From: Sue Howell
Sent: 13 November 2017 15:02
To: Planning.Responses
Cc: David Easton
Subject: RE: Planning Consultation on: A/169/17/OUT

Comments from Greenspace

This application A/169/17/OUT is a resubmission of detail submitted under application A/44/17/OUT. We would reiterate our consultation comments as follows:

APPLICATION **A/169/17/OUT**

MASTER PLAN

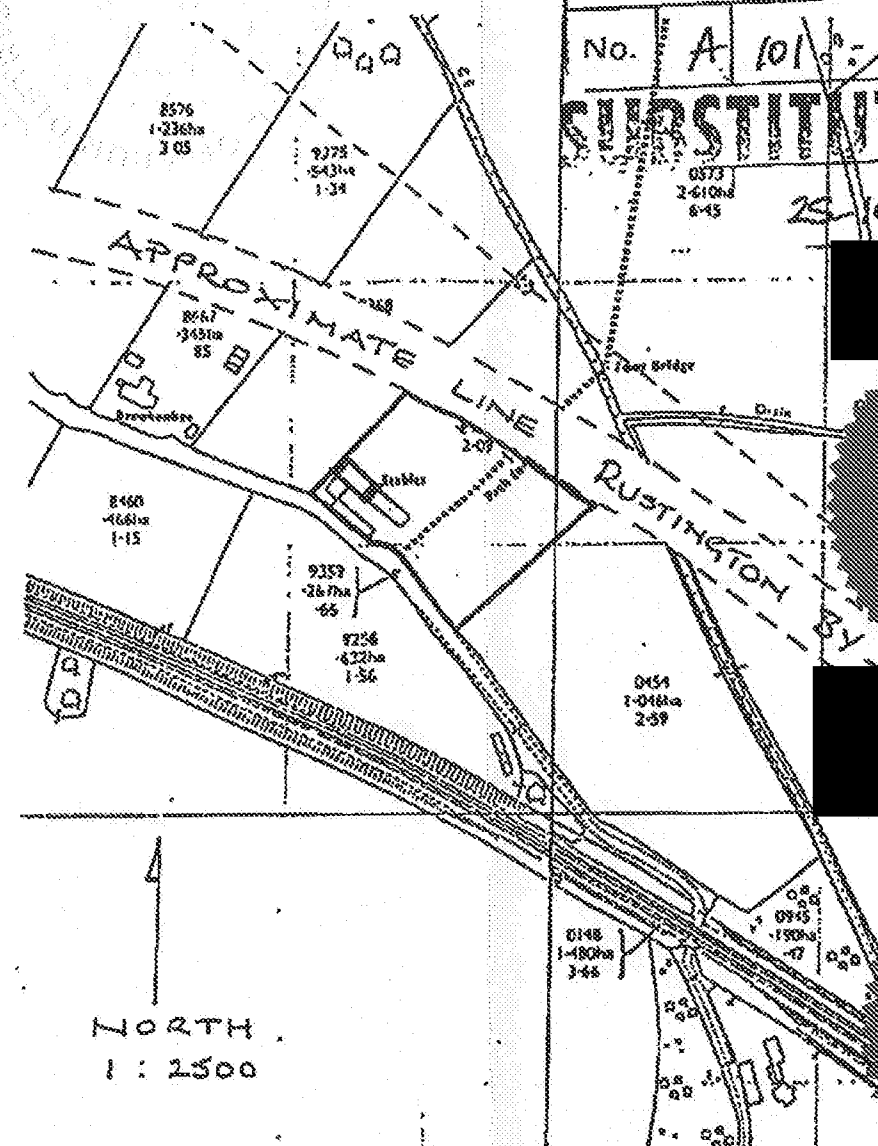
The provision of landscaping for the development must be conditioned with any permission. Some indicative landscaping particularly trees detailed have been illustrated with the masterplan. Forming part of any decision consideration or as a minimum reserved matters a full landscape scheme should be submitted for approval, detailing species choice, position, densities and size at time of planting. This should be plotted in plan and list form and in relation to the trees and vegetation to be retained in the locale, so that a clear picture of the proposals can be seen. These details are required to assure the adjacent land setting is maintained, the setting is uncompromised and the proposals are appropriate to its setting also its proximity in relation to neighbouring properties and South Downs National Park to the North. Landscaping would be required as a buffer and considered acoustic buffer because of the sites location between railway line and roadway. The existing hedgerows on the site would need to be retained and enhanced and any gaps filled using native hedge species the purpose of these to create wildlife corridors across the site The landscape scheme should maximise the biodiversity of the site with the inclusion of native species and the retention of a variety of habitats. The long term management of the developing landscape would need to be considered.
